**Kemps Creek Estate - Mod 3 Response to Submissions (SSD-9522-MOD-3)
657-769 Mamre Road, Kemps Creek**

Thank you for providing Council with the opportunity to comment on the proposed State Significant Development (SSD) modification application. The following is provided for the Department's consideration.

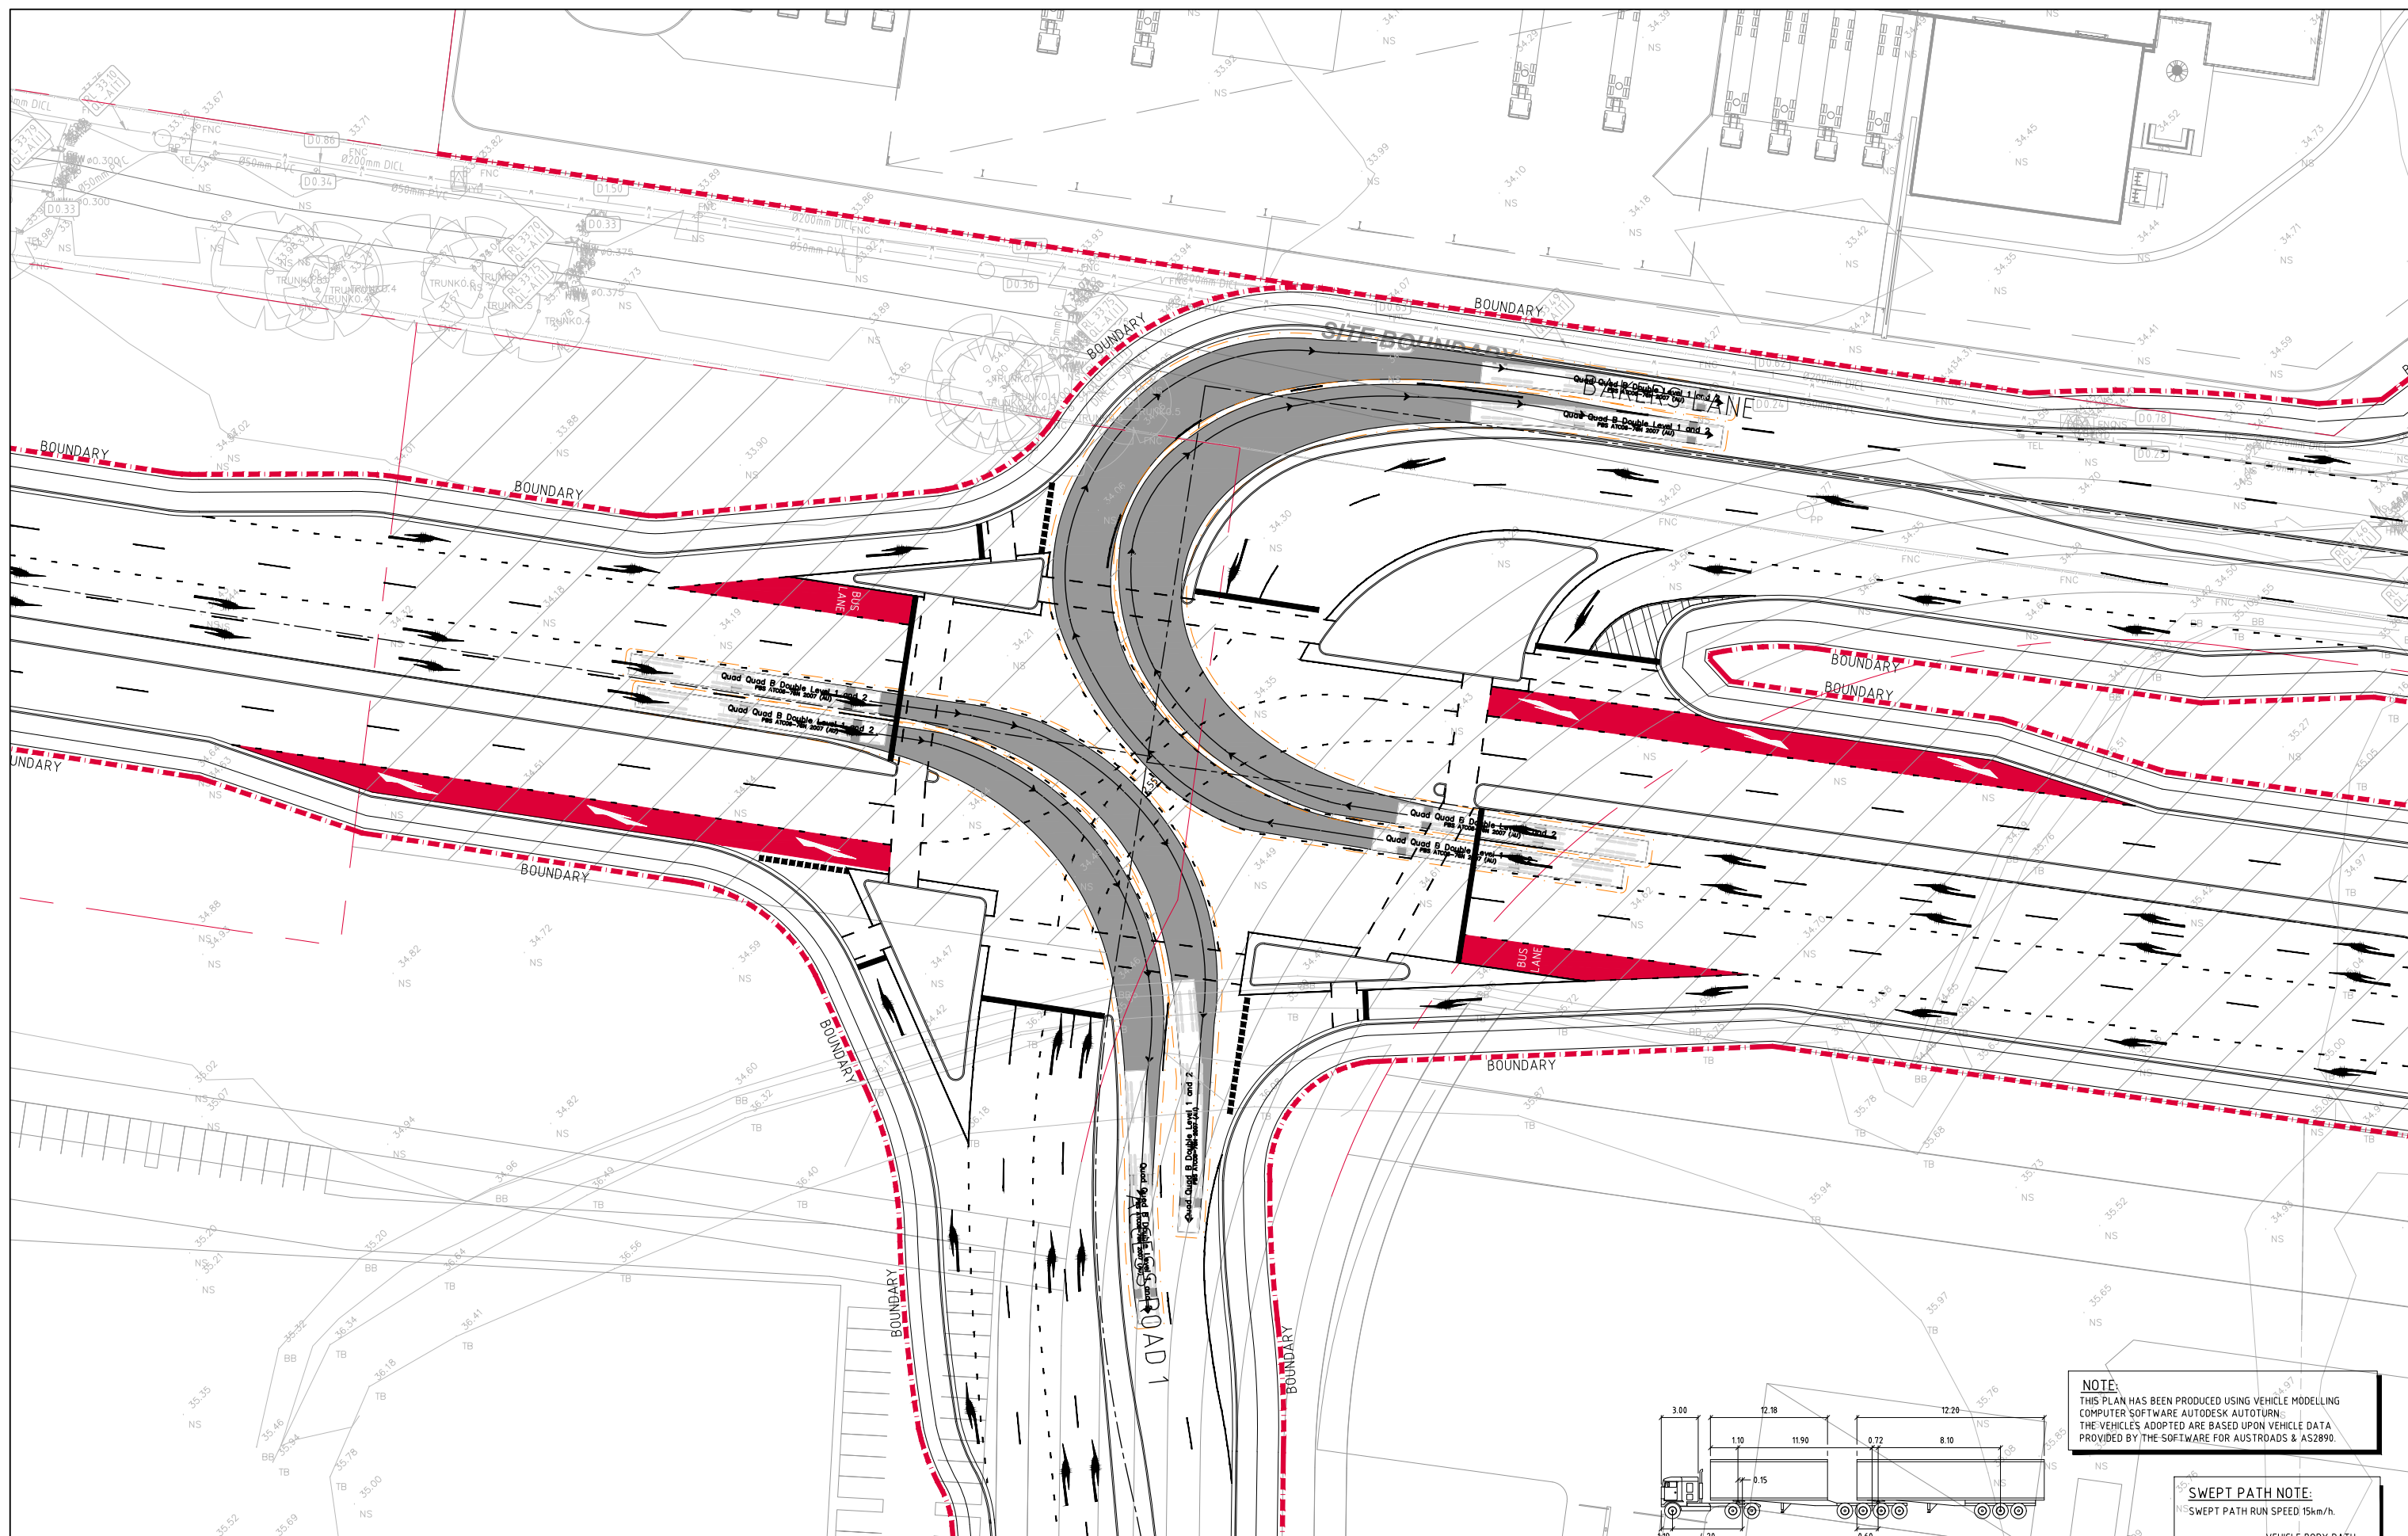
'Council recommends that Lot 3 truck swept paths (Sheet AG15) are to be modified to show that a truck can turn around while there are parked trucks'.

The applicant states that truck will be side loaded and thus no manoeuvring area is required. It is raised that the site will be utilised by numerous tenants over the life of the development and that adequate truck turning facility is to be demonstrated for worker safety and futureproofing reasons.

The Department will need to be satisfied that truck turning whilst parking bays are in use is not accommodated.
